Recommendation Report for Planning Permission for Works or Extension to a Dwelling

REF NO: FP/102/20/HH

LOCATION: 2 Westmorland Drive
Felpham
PO22 8LX

PROPOSAL: Two storey side extension.

DRAWING BLOCK PLAN DATE: JUNE 2020 DRAWN: T. Murray	SCALE 1/500
DRAWING: 20/35/3	REVISION:

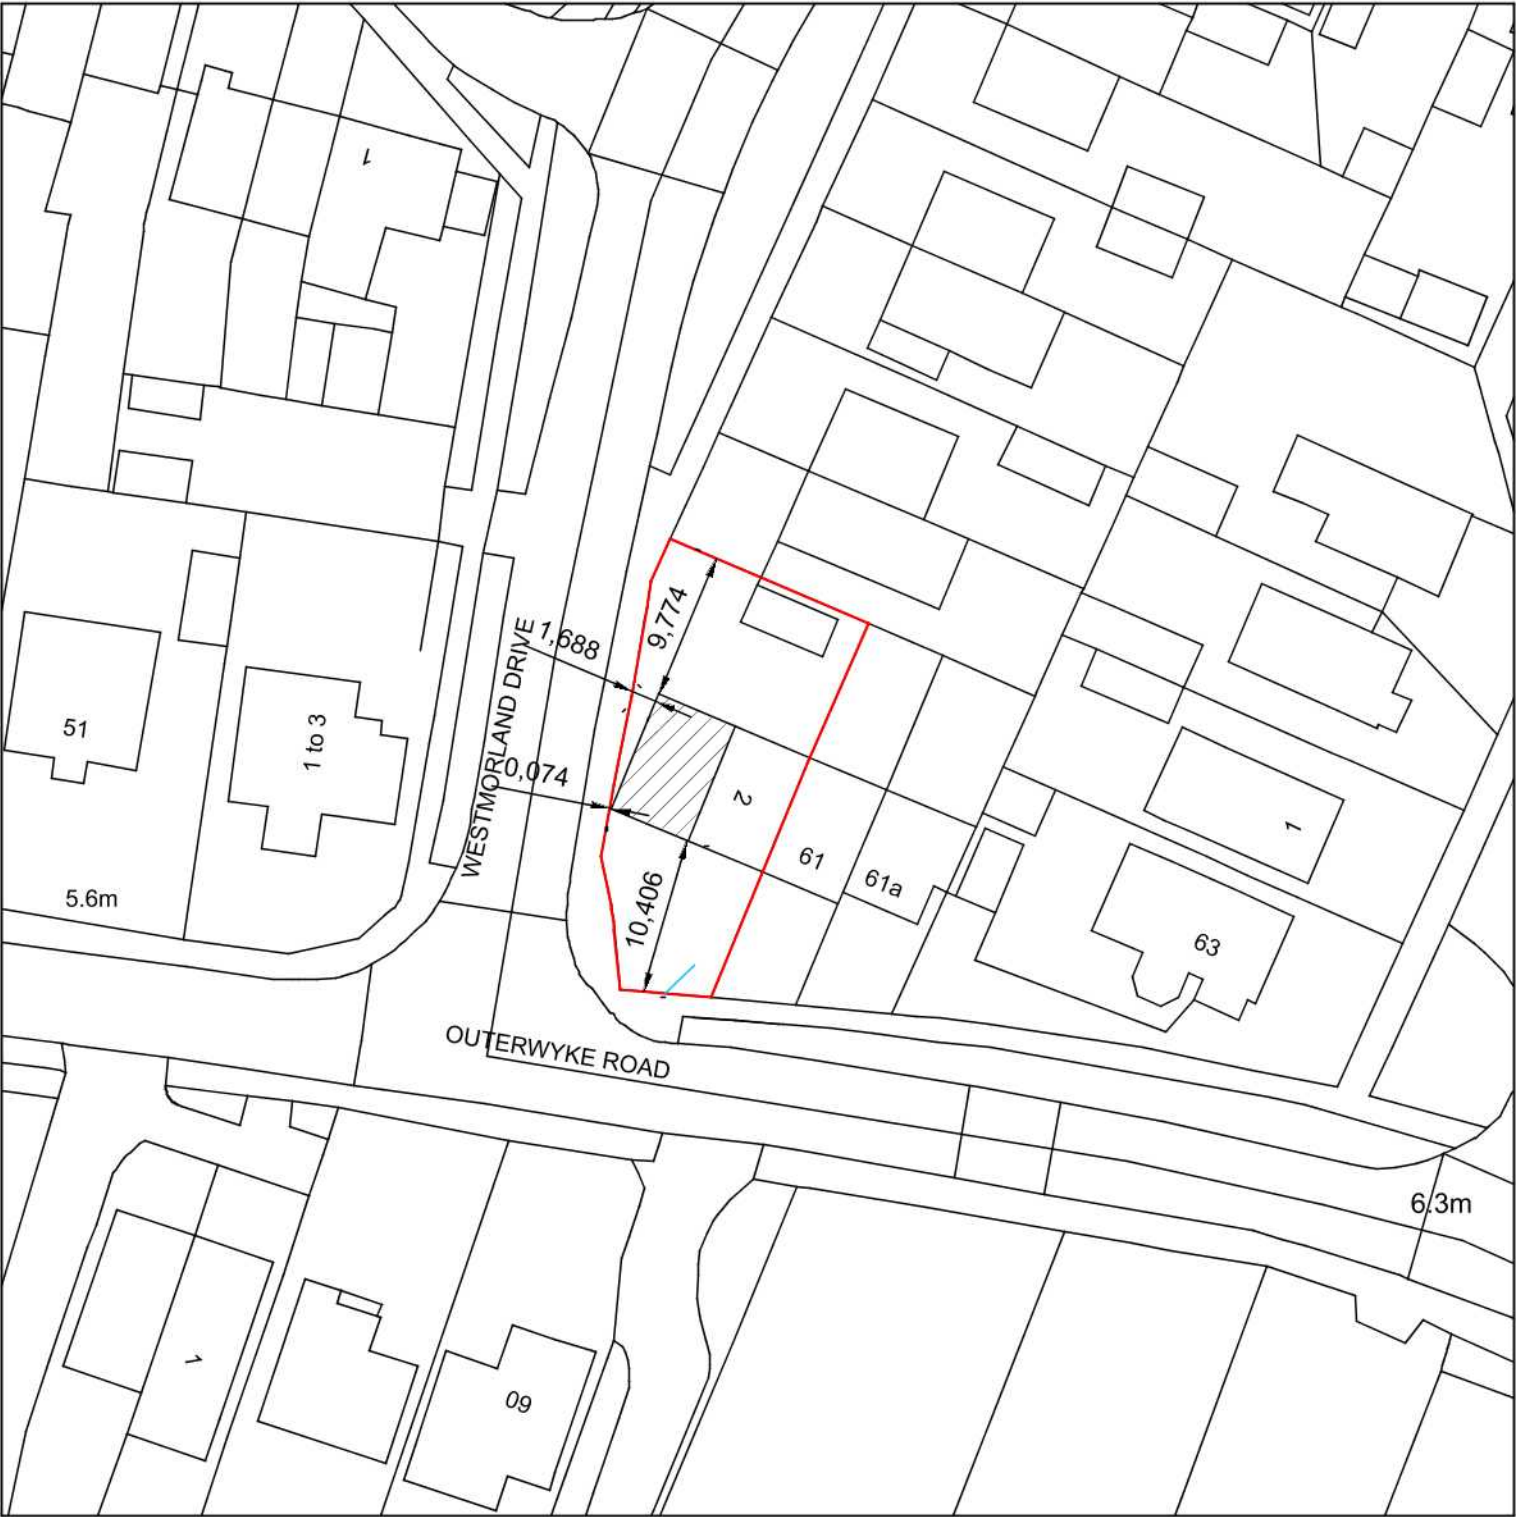
The development is out of character with surrounding properties which are predominately uniform in character set back from the street scene, in contrast to the proposal which retains only 0.07m to the western boundary and footpath.

DRAWING PLANNING	SCALE 1/100
DATE: JUNE 2020	
DRAWN: T. Murray	
DRAWING: 20/35/2	REVISION:

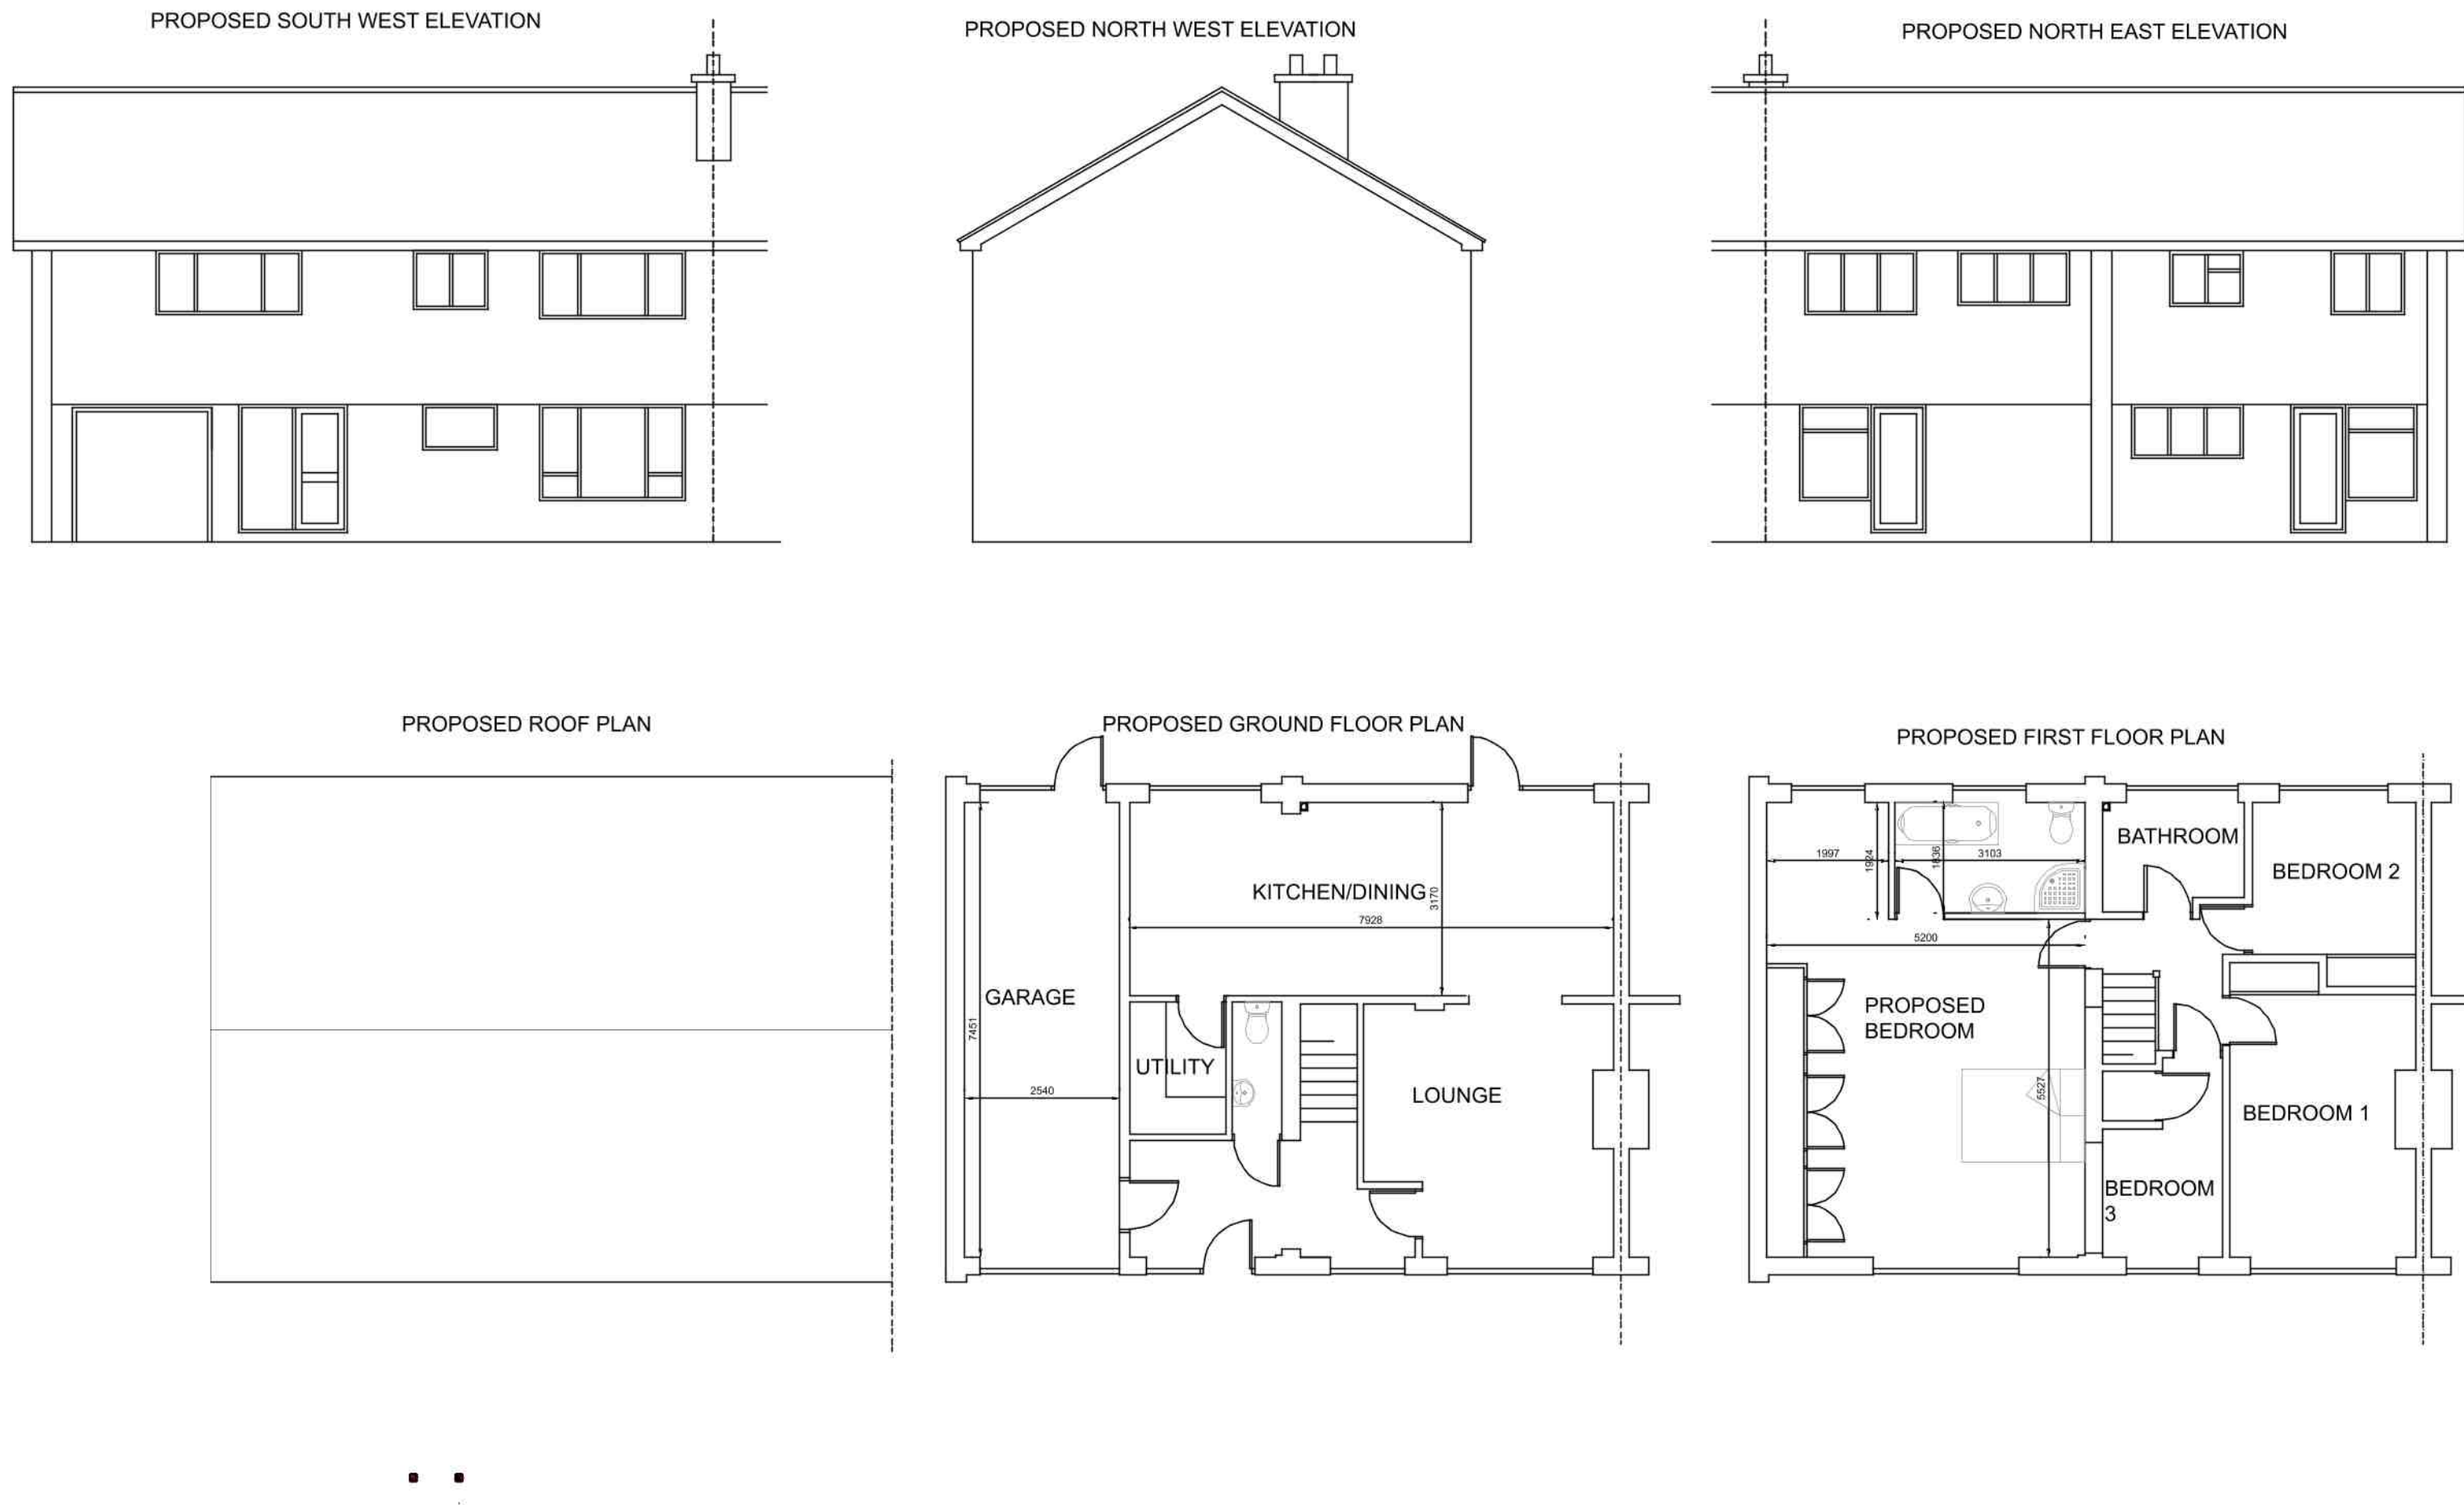
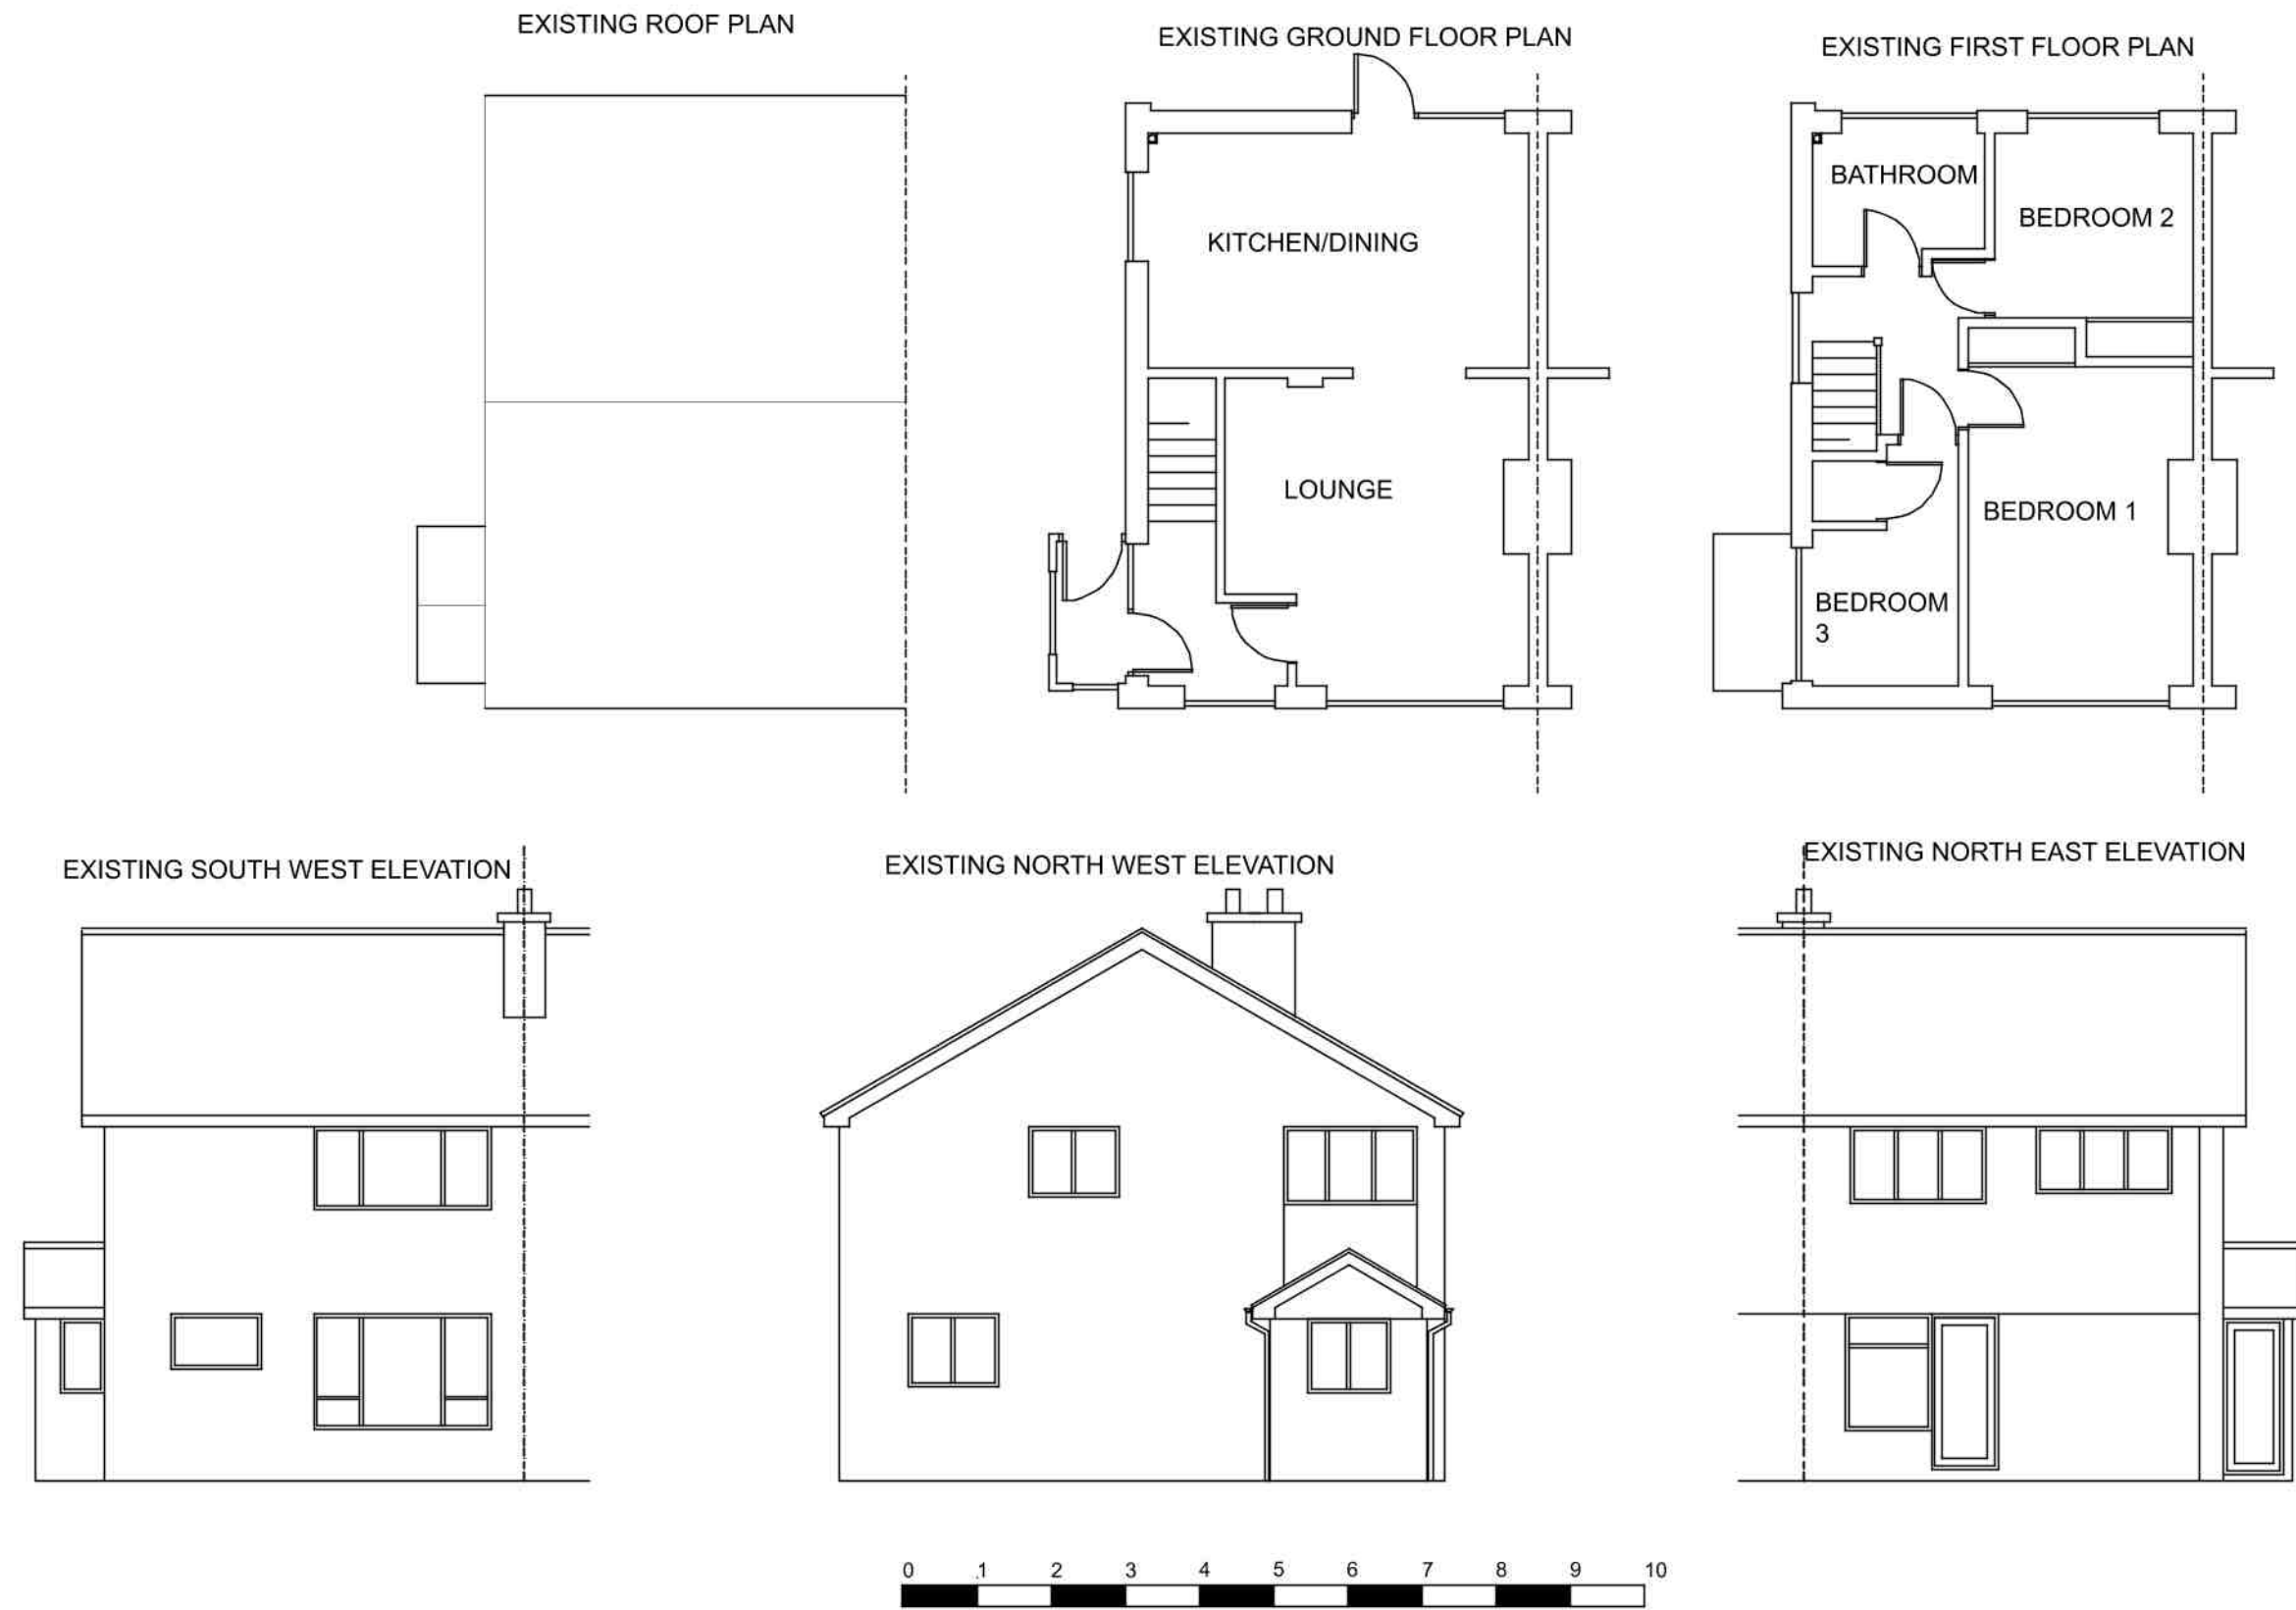
The proposal seeks to construct a two storey side extension to the west elevation. There is a porch which serves as the main entrance which will be removed and the front door re-located to the south. The property is on a corner fronting Outerwyke Road and Westmorland Drive and is highly visible.

The extension will run along the full side elevation meeting with the rear building line with the roof line extending to match that of the host dwelling.

The proposal is considered to have a significant presence in the street scene and wider area as a result of its siting. The extension will have a width of approximately 4.55m which adds significant bulk to the side of the property and as a result it is considered to appear unduly dominant upon the street scene due to the significant scale proposed.

As a result of its open and prominent location, the bulk and scale of the proposed development is deemed to result in an adverse impact upon the spatial pattern and character of the area and is in conflict with policies D DM1 (1) and D DM4 (a) & (e) of the Arun Local Plan and Policy ESD1 of the Neighbourhood Plan.

To the rear elevation there are 2 additional first floor windows proposed. These would look towards the side elevation of the 4 Westmoreland Drive to the rear however is not considered to give rise to adverse overlooking. There are no windows to the side elevation.

- 1 The development has a detrimentally harmful impact upon the established character of the host dwelling, and its wider locality as a result of its significant bulk and siting, in conflict with D DM1 (1) and D DM4 (a) and (e) of the Arun Local Plan and ESD1 of the Felpham Neighbourhood Plan.
- 2 **INFORMATIVE:** Statement pursuant to Article 35 of the Town and Country Planning (Development Management Procedure)(England) Order 2015. The Local Planning Authority has acted positively and proactively in determining this application by identifying matters of concern with the proposal and determining the application within a timely manner, clearly setting out the reason(s) for refusal.
